SUBJECT: SFD2312-0202
SINGLE FAMILY DWELLING

Here are the results of all Inspections located at **3584 OLD US 421:**

Inspection Type: ROUGH IN
Scheduled Date/Time: 6/11/2024
Completed Date/Time: 6/11/2024
Inspector: Daniel L Floyd
Result: FAIL W/ PENALTY
Remarks: eTRAKiT Inspection Request
Notes: 6/2/2024 12:52 PM Jonathan Taylor

Sheet Number
S1
 5 of 11

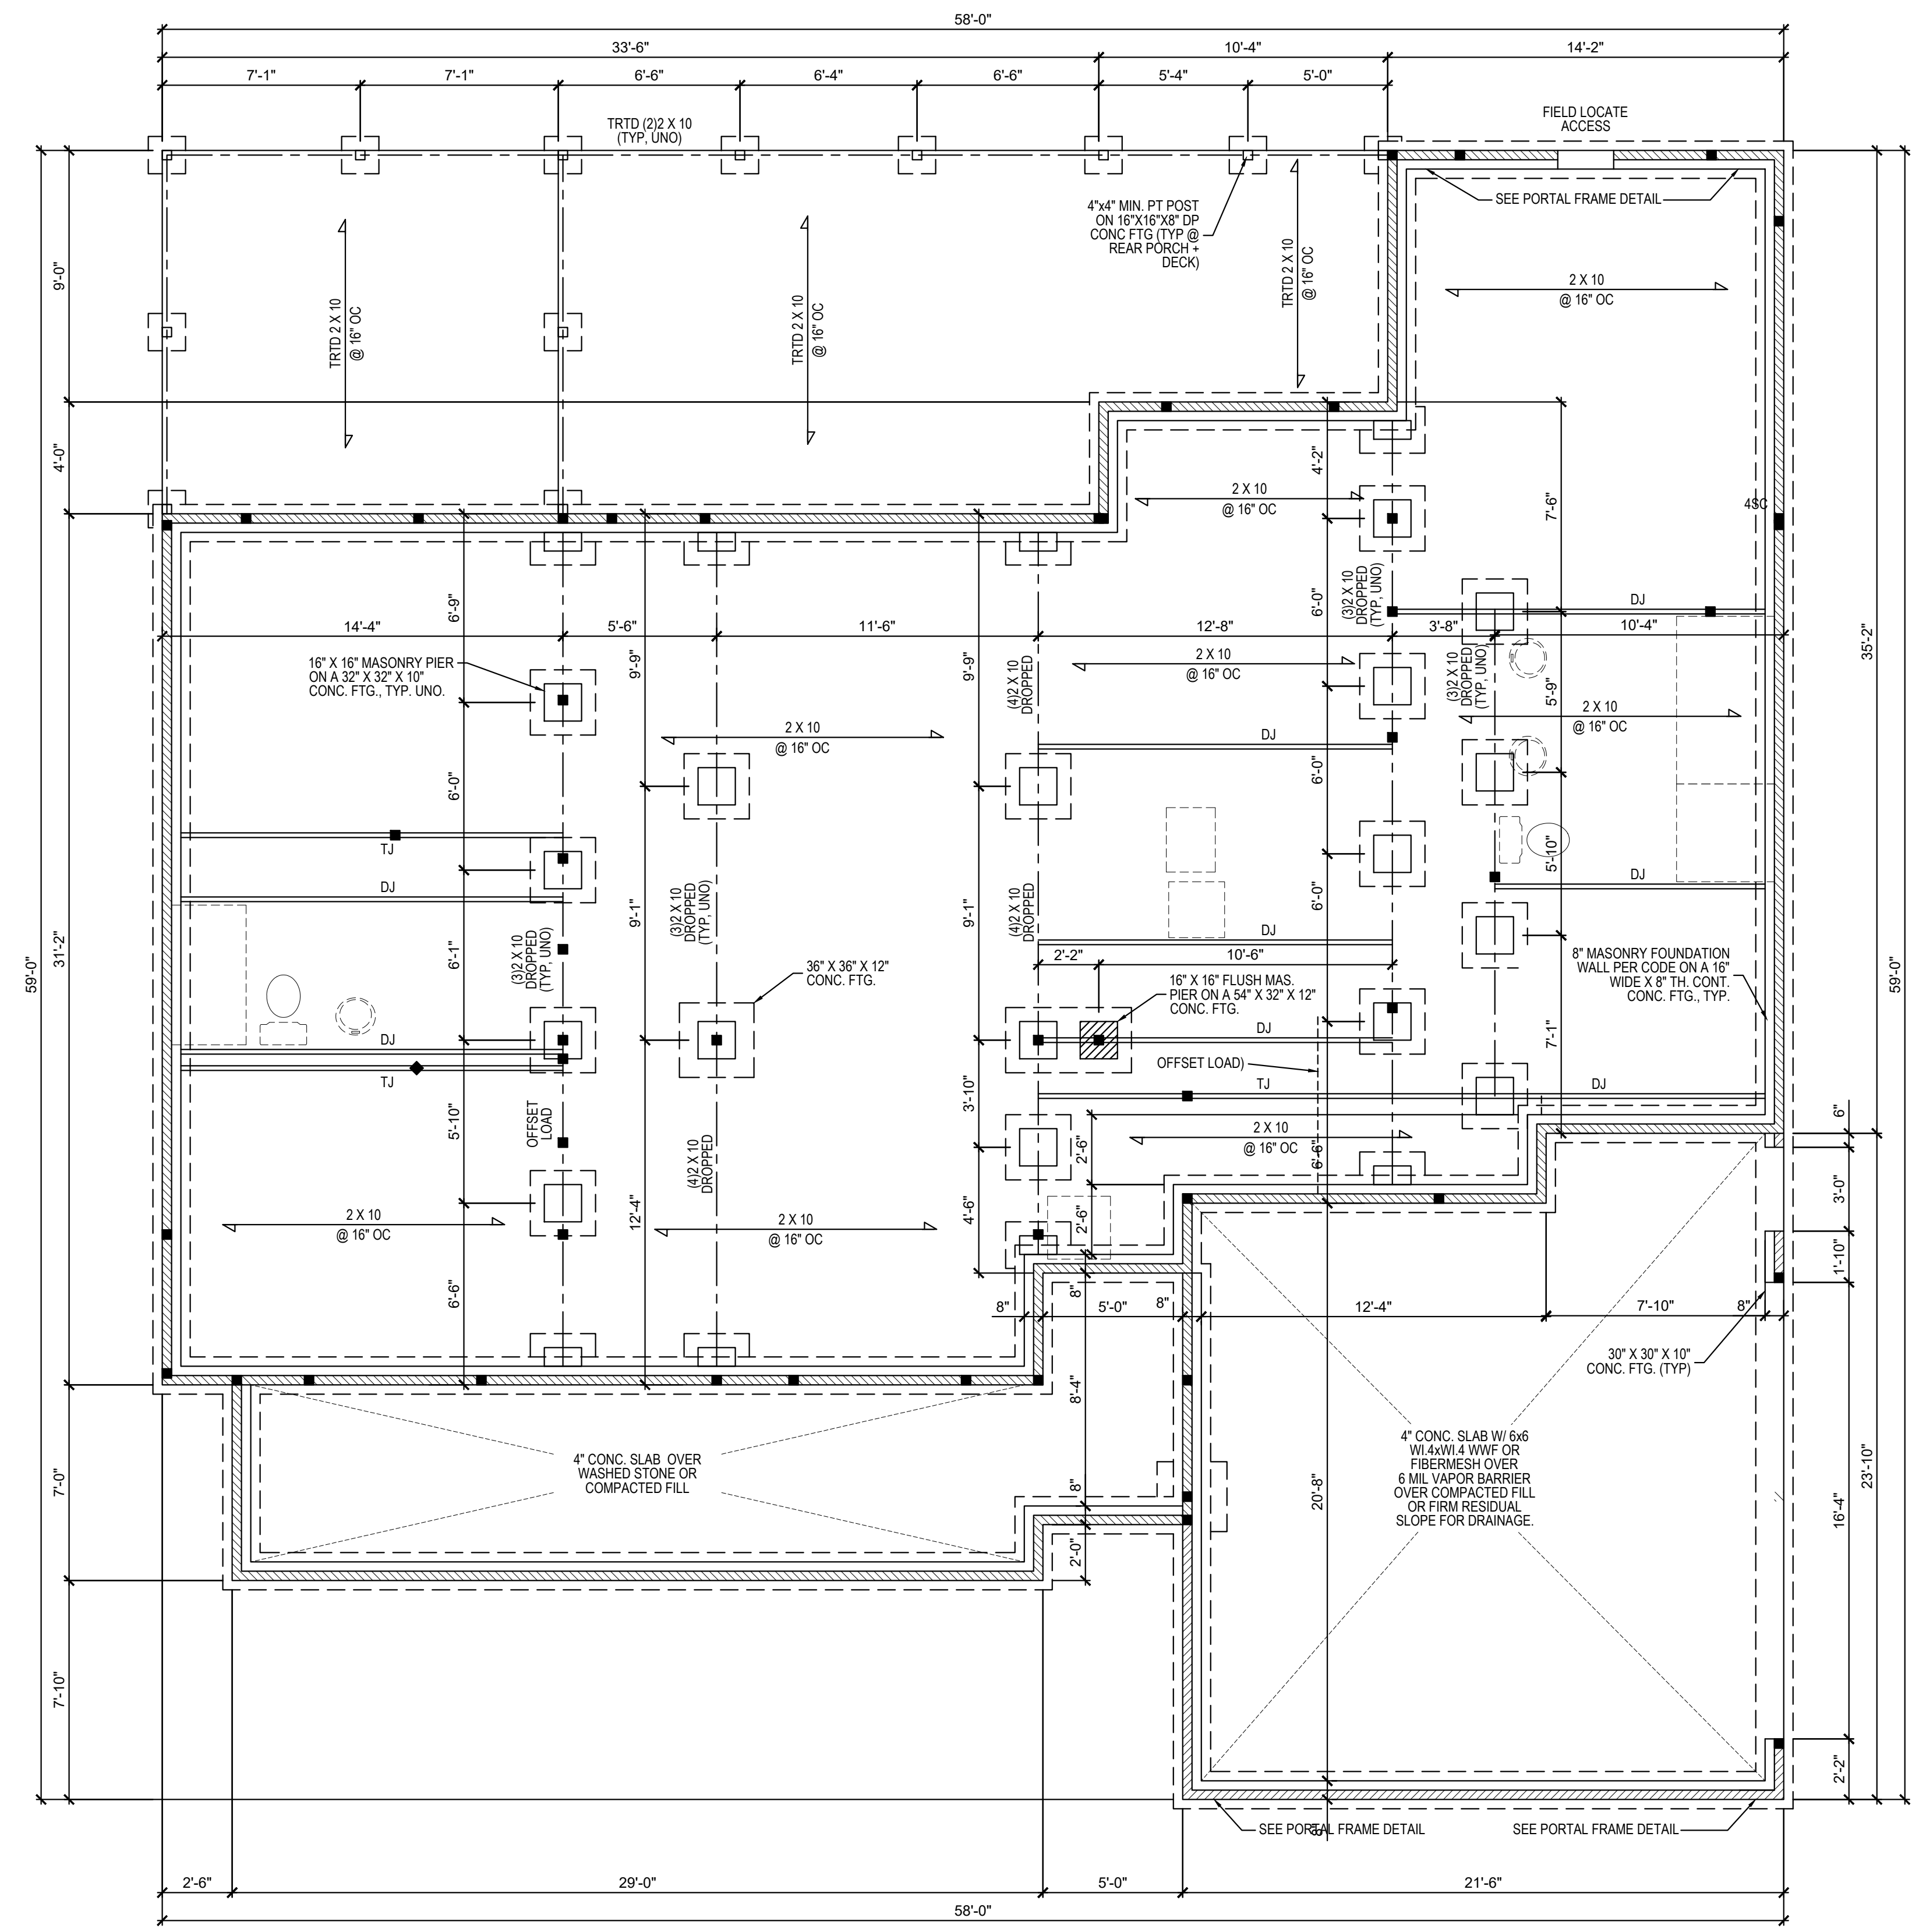
1. Missing windows upstairs and back doors and front door all unprotected
2. Missing 2x2 washers and nuts on anchor bolts
3. Missing 6sc under garage door header as plans call for

Sheet Number: **S2**
 6 of 11

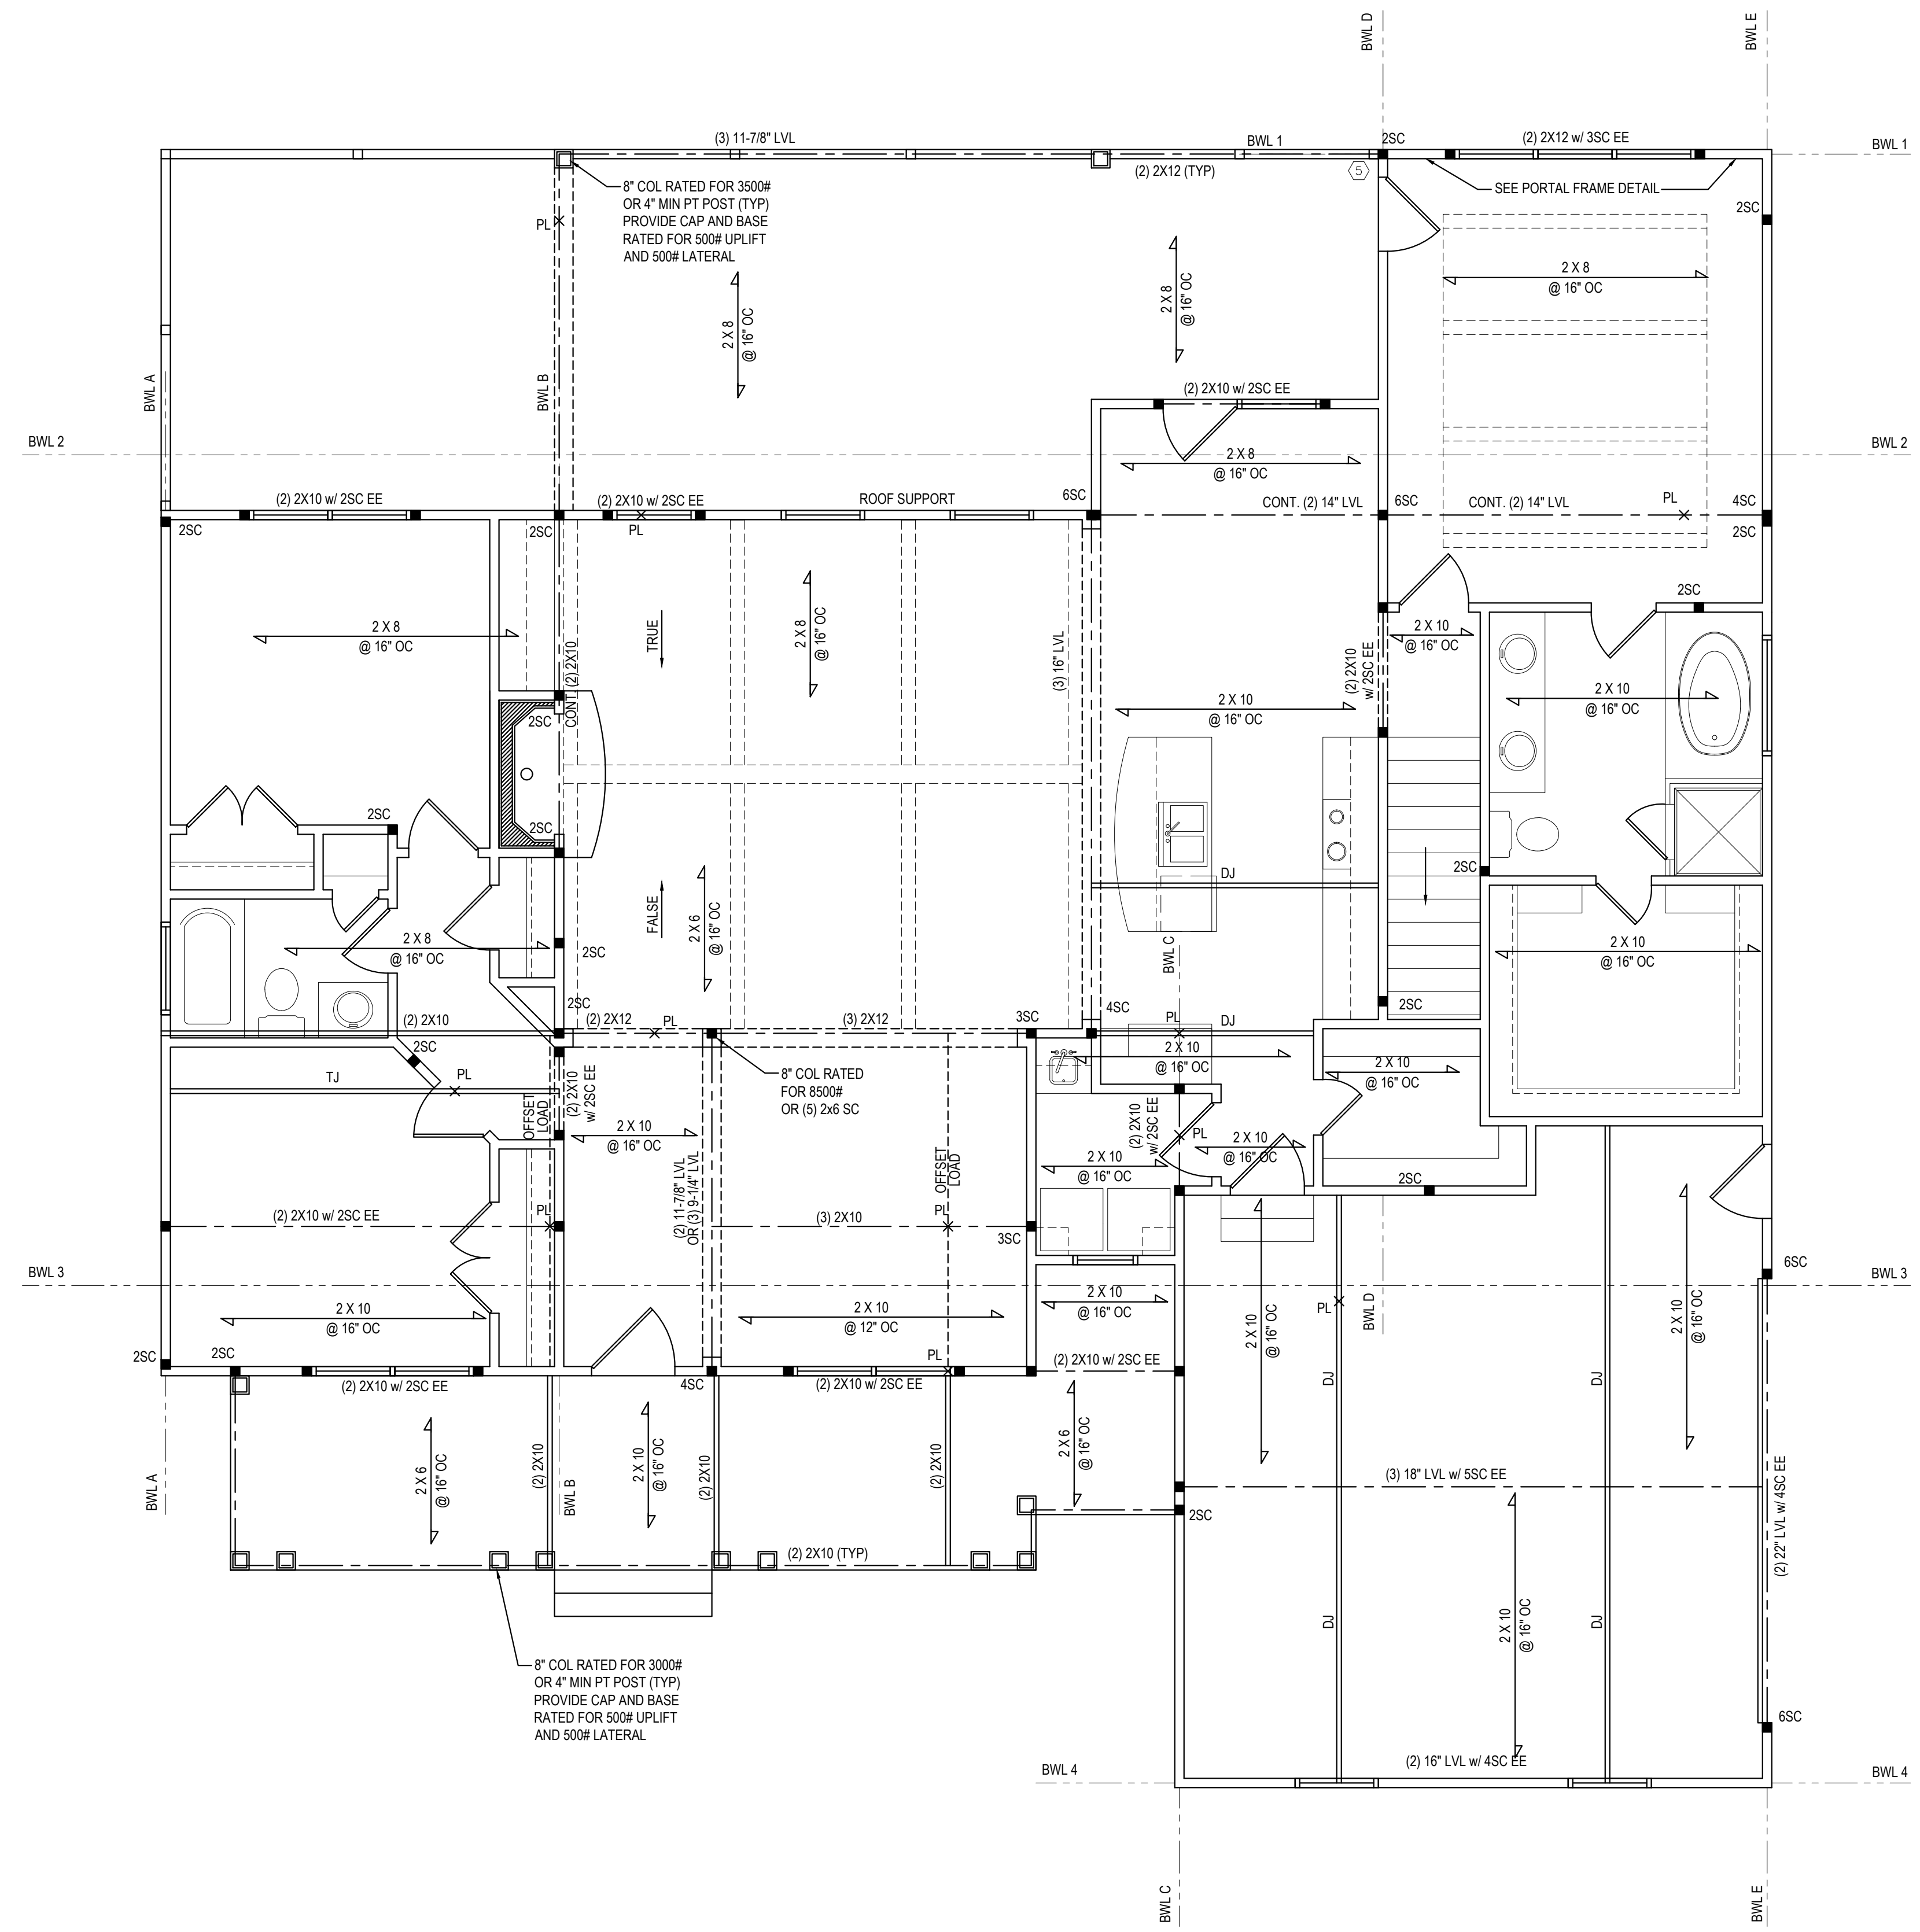
4. Need lvl documents and documents stating it's ok to drill through the 3 ply lvl in the garage
5. Missing 2sc on left side garage wall as plans show
6. Seal holes in air barrier between the garage and house

10. Stud columns in master bedroom need to match the plans
11. Structural post in dining room does not match the plan
12. Seal holes in the air barriers above the living room walls
